MERCER ISLAND CENTER FOR THE ARTS

Mercer Island Center for the Arts
SEPA Submission 1.23.2017 revised 2.16.17
Additional Information; Response to Public Comments and Peer Reviews

2. Response to ESA Memorandum to Scott Greenberg dated 9.20.16 regarding Wetland Buffer Impacts and Mitigation Review

| SHEET NUMBER: W1 OF 1 | SHEET NUMBER: W1 OF 1 |

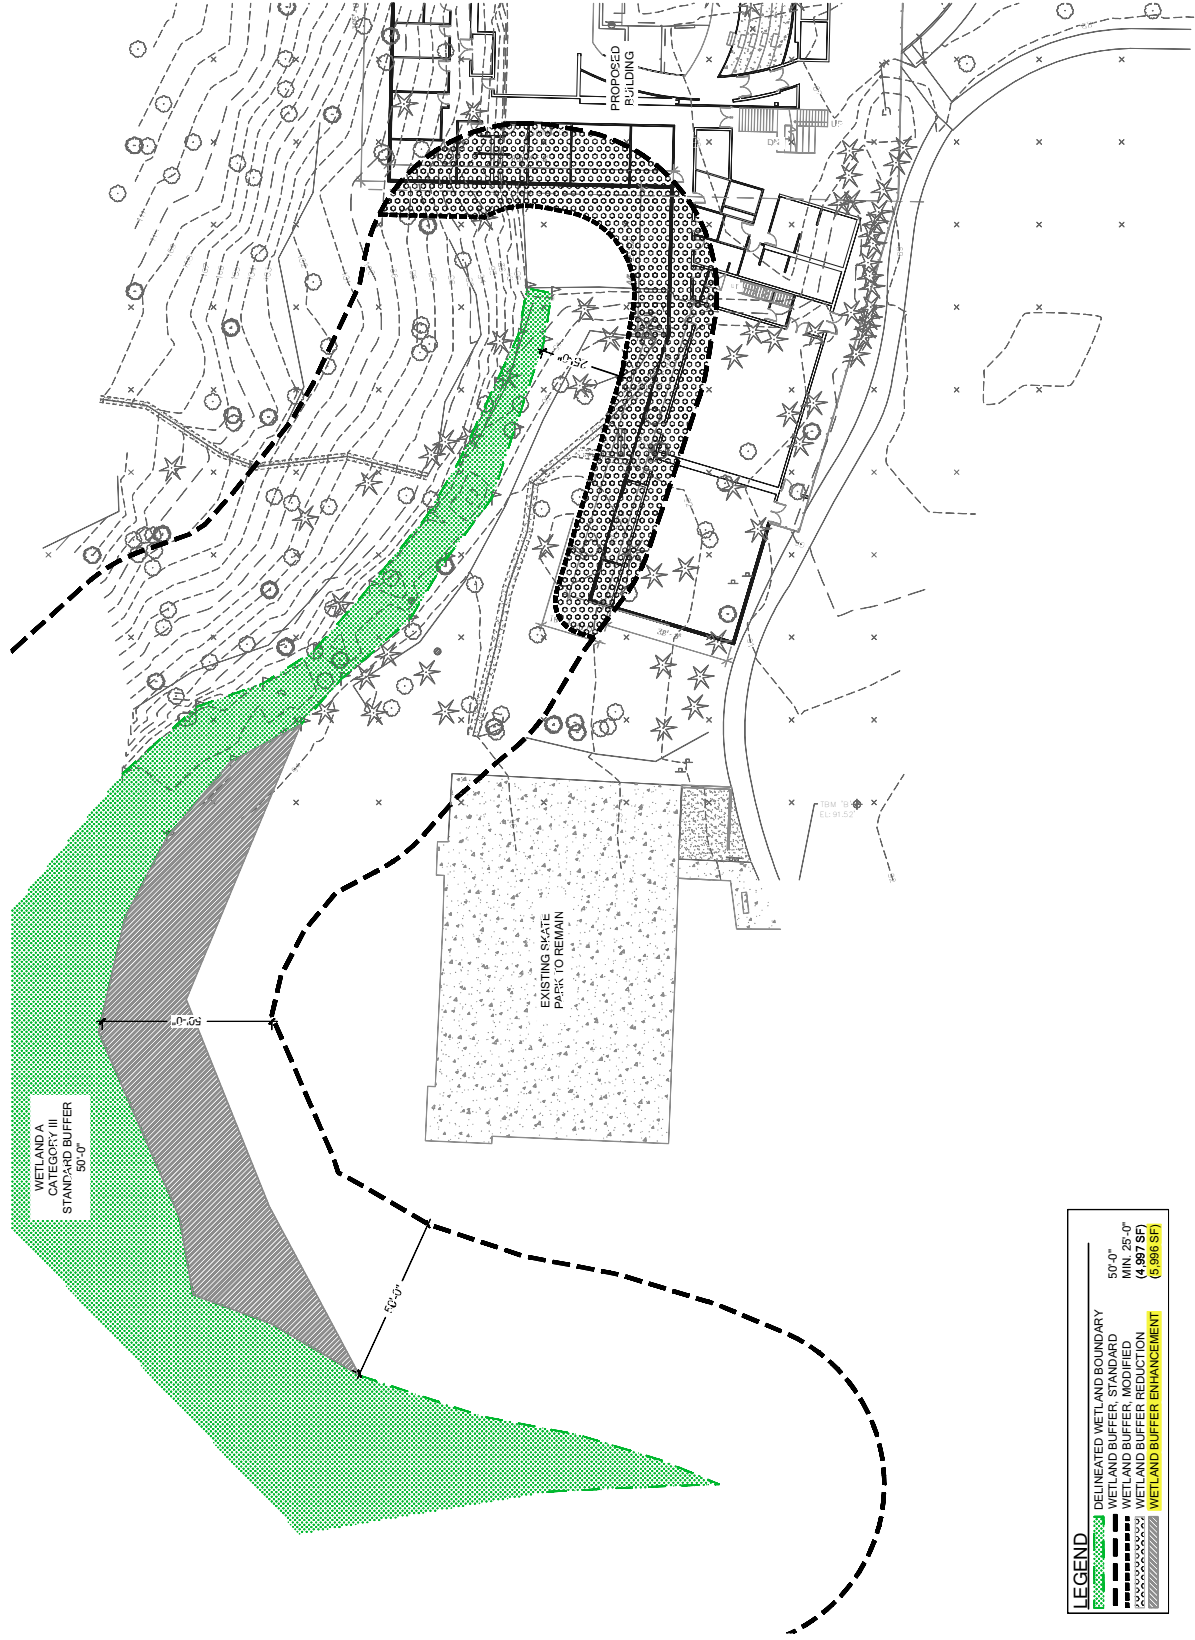
Comment: Sheet W1 of 1 shows a buffer reduction at the north end of the wetland. The buffer will be reduced from 50 feet to 25 feet, which is the minimum width allowed MICC 19.07.080(C)(1). Buffer reduction would reduce the buffer area by 4,997 square feet. Proposed buffer reduction activities should be documented in a buffer mitigation plan. The proposed buffer reduction must account for the bioretention area and access road “stub” as described above.

Comment: To mitigate for buffer reduction, the applicant proposes to enhance 5,996 square feet of buffer located about 80 feet south of the reduction, adjacent to the east side of the wetland (Sheet W1 of 1). Buffer enhancement is an approved mitigation activity that offsets loss of buffer functions associated with buffer reductions MICC 19.07.080(C)(2). To better understand if the proposed mitigation complies with MICC, the applicant should provide a more detailed mitigation plan. ESA recommends a buffer mitigation plan that provides applicable information listed in MICC 19.07.050(C).

Response: A detailed mitigation plan has been prepared concurrent with this response letter. The plan includes details regarding areas of enhancement, as well as maintenance and monitoring protocol. All stormwater facilities (bioretention is no longer proposed due to high water table and soil conditions) and the access road ‘stub’ mentioned in the comment are to be positioned outside of the reduced buffer area.

Response: The submitted plan was prepared only to a conceptual level and was not intended to be a final permit-ready plan. A detailed mitigation plan

has now been prepared concurrent with this letter. The plan details areas of proposed enhancement and includes applicable information required by MICC 19.07.050.C. In addition, a critical area study has been prepared that documents compliance with the buffer reduction criteria in MICC 19.07.080.C.2.

Attachment L
Site & Paving Plan

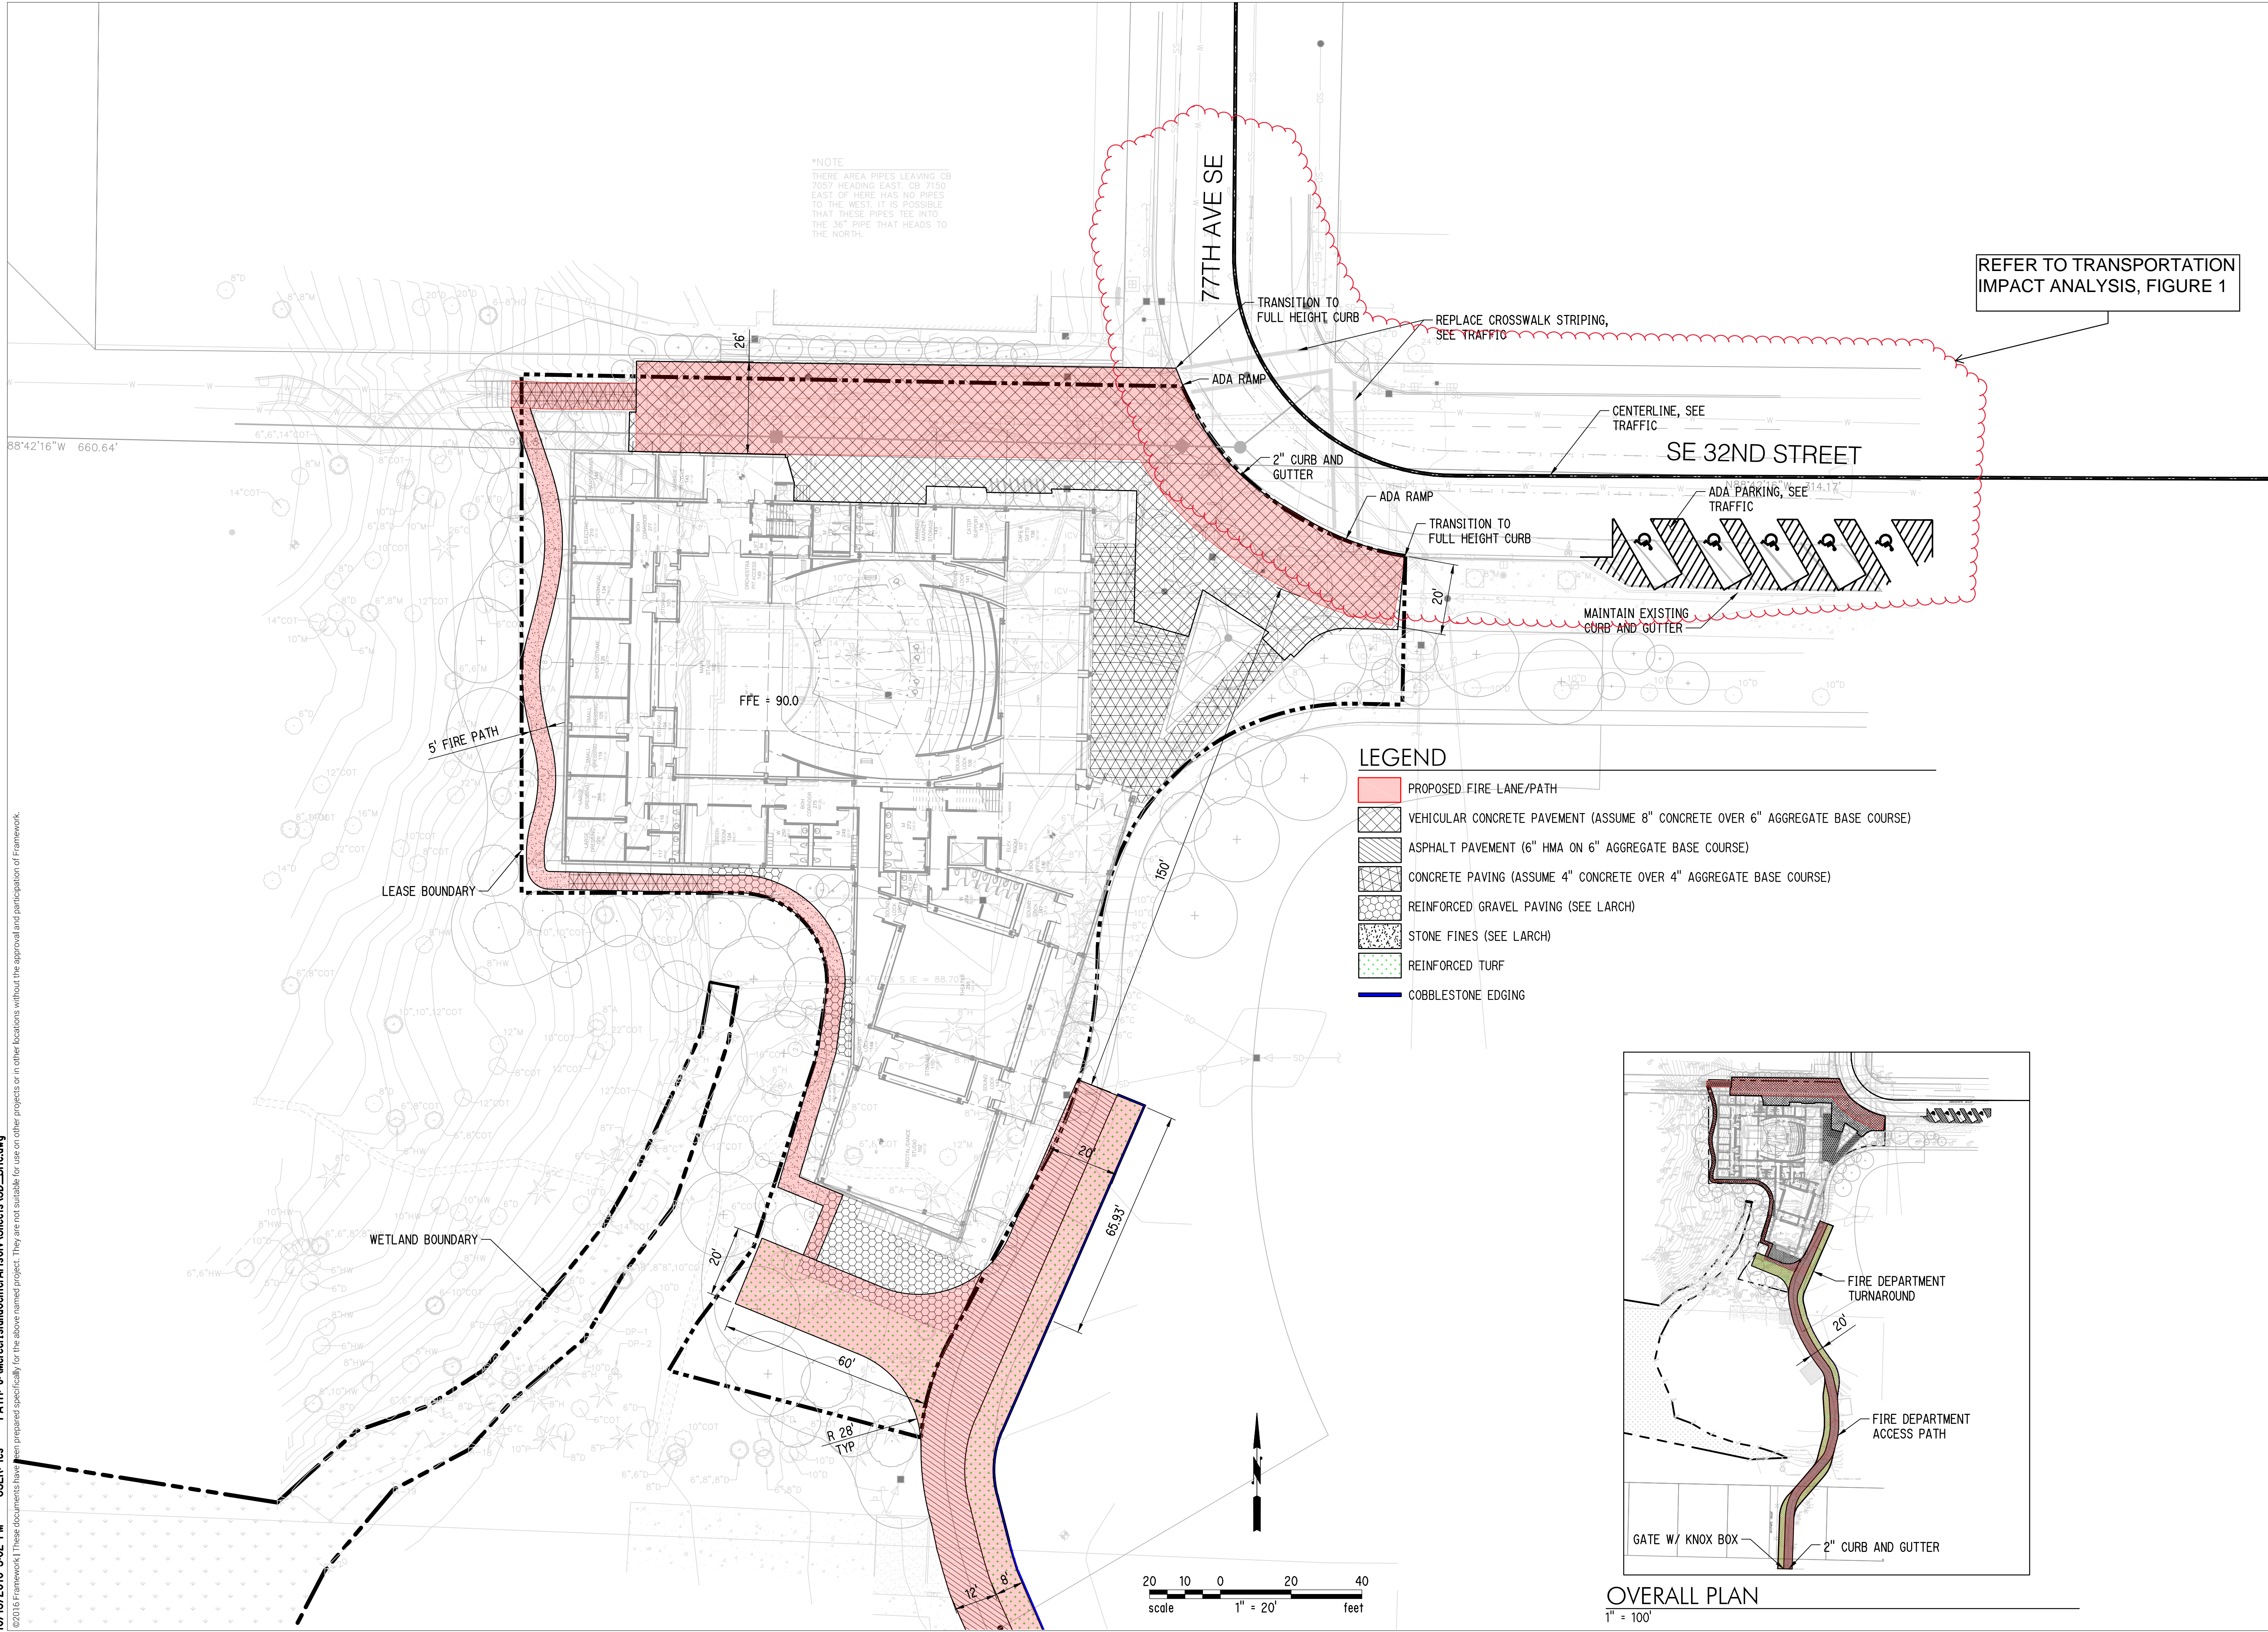
Comment: Concern regarding grading within the wetland /wetland buffer

The following was prepared in coordination with MKA civil engineers. In addition, please reference SEPA Checklist Attachment and . Note that the plans and SEPA checklist that were reviewed by ESA have been modified since their review. The current version of the Site and Paving Plan is shown as Attachment L to the SEPA.

Response: The existing wetland has been categorized as a Class III with a 50-foot buffer. There will be no grading within the wetland.

The project proposes to reduce the buffer on the north end as well as the northeast corner to 25 feet. The reduced buffer area has been calculated and will be mitigated through buffer averaging by adding to the buffer in areas to the south. Disturbance within the buffer will include removal of the asphalt paving, minimal grading and planting of native species according to the wetland mitigation plan prepared by The Watershed Company. No grading will occur in the wetland.
